CITY OF ALBUQUERQUE

March 11, 2025

RE: 2500 Phoenix Ave. NE
Menaul & Vasser
Grading & Drainage Plan
Engineer's Stamp Date: 01/03/2025
Hydrology File: H16D156
ABQ-PLAN File: HYDR-2025-00060

MENAU AND VASSAR
 2500 PHOENIX AVE NE, ALBUQUERQUE,
 NM, 87107
GRADING AND DRAINAGE PLAN

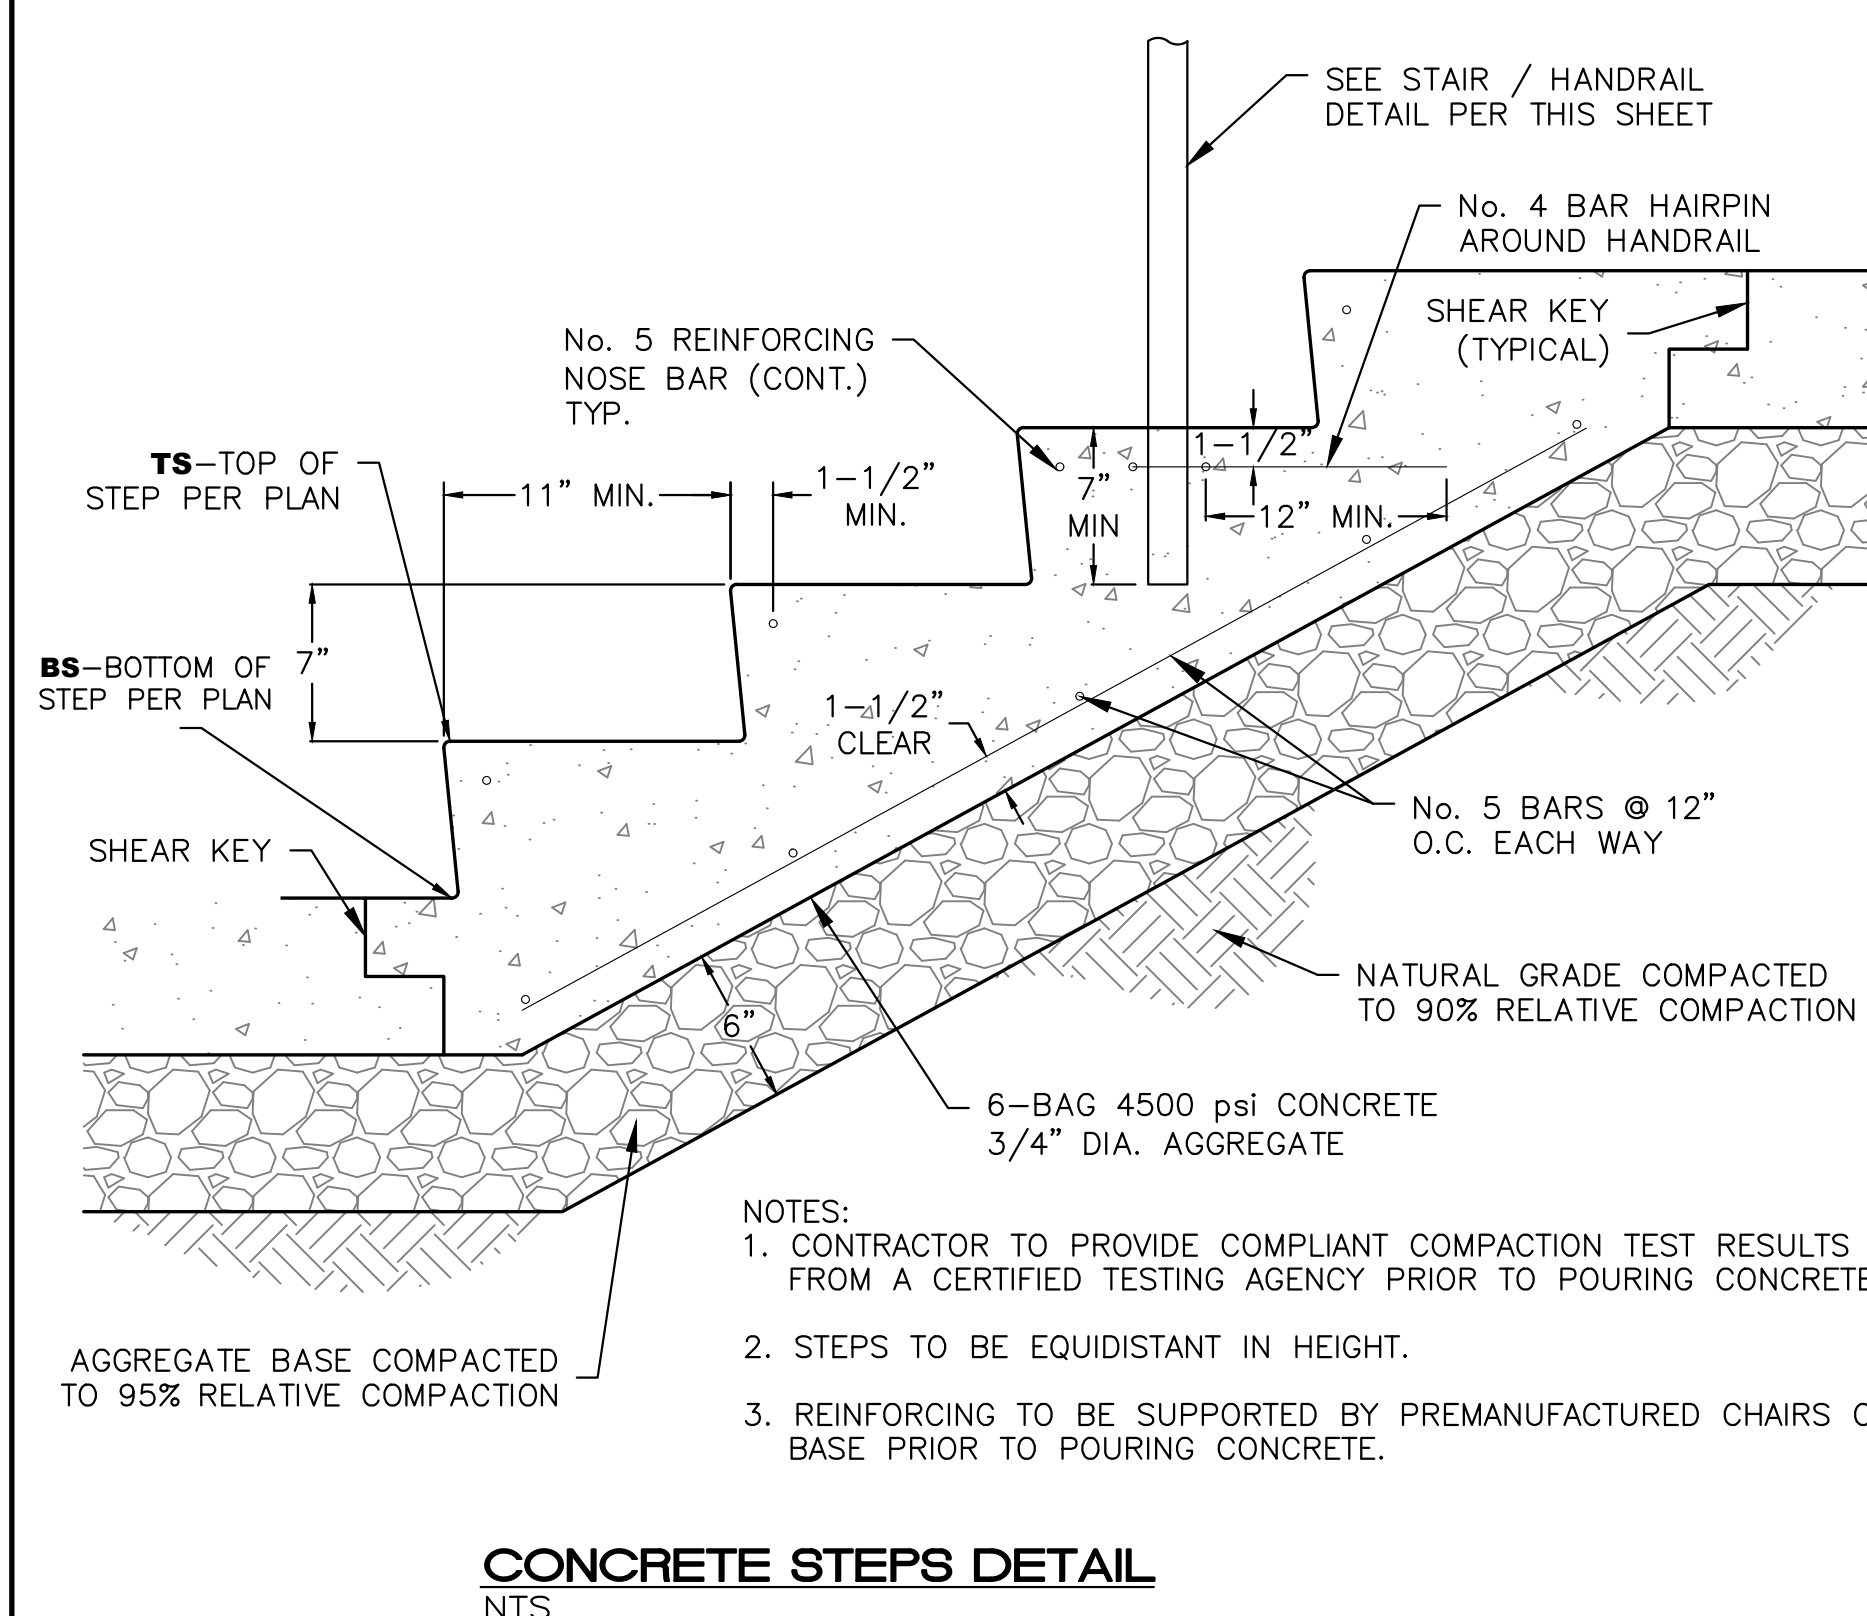
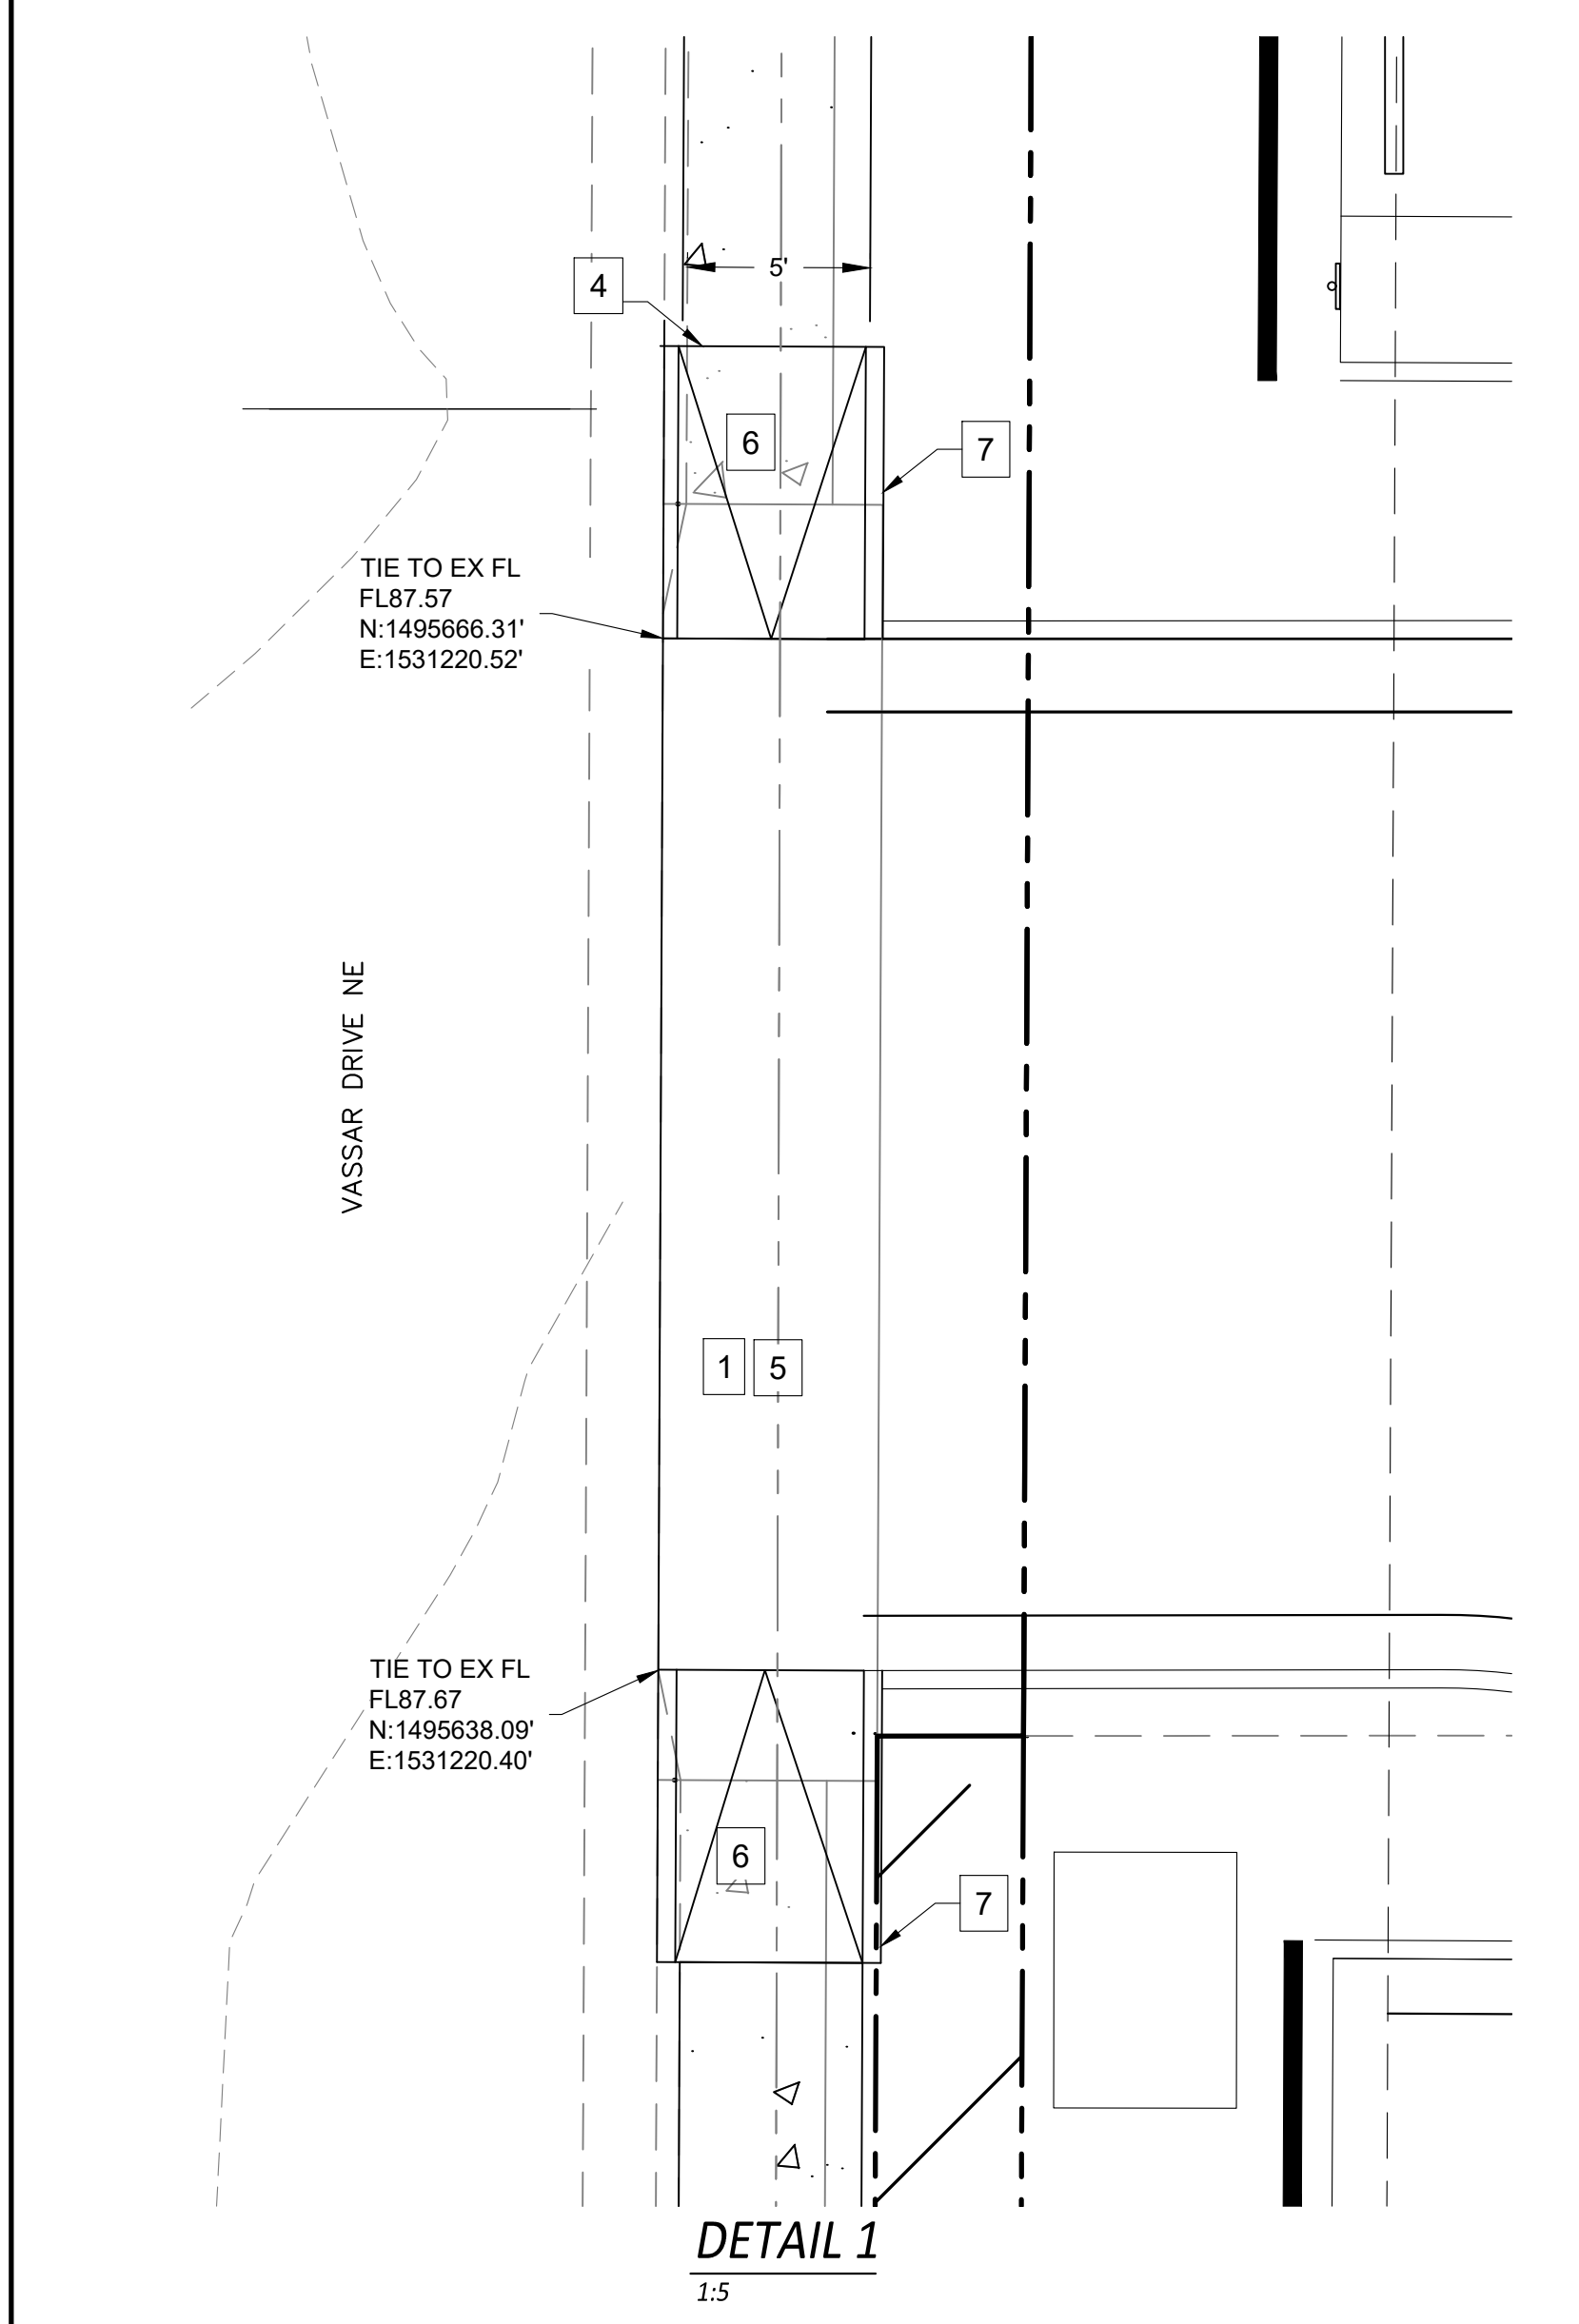
5. Sheet C2.0: Review and revise all slope percentages and directional arrows to ensure correctness. There appears to be incorrect slopes and arrows near Section C-C and Section B-B where retaining walls are proposed.

6. Sheet C2.0: Review and revise all callouts for spelling, in particular, for the 6" aggregate base course description.
7. Sheet C2.0: Review and revise all Legend and Plan information and depictions regarding Base Course and Gravel.

8. Sheet C2.0: From field observations, the existing 30' Private Access and Drainage Easement appears to be providing access to the property/parcel/business to the east of this project which would be adversely affected by the proposed retaining wall, both for vehicular access and stormwater conveyance.
9. Sheet C2.1, The Existing Basin Map: From field observations and topographic mapping review, said Existing Basin Map should be reviewed and revised to reflect actual existing conditions.
10. Prepare and provide a response to each of the above items in a subsequent resubmittal for further review is required.
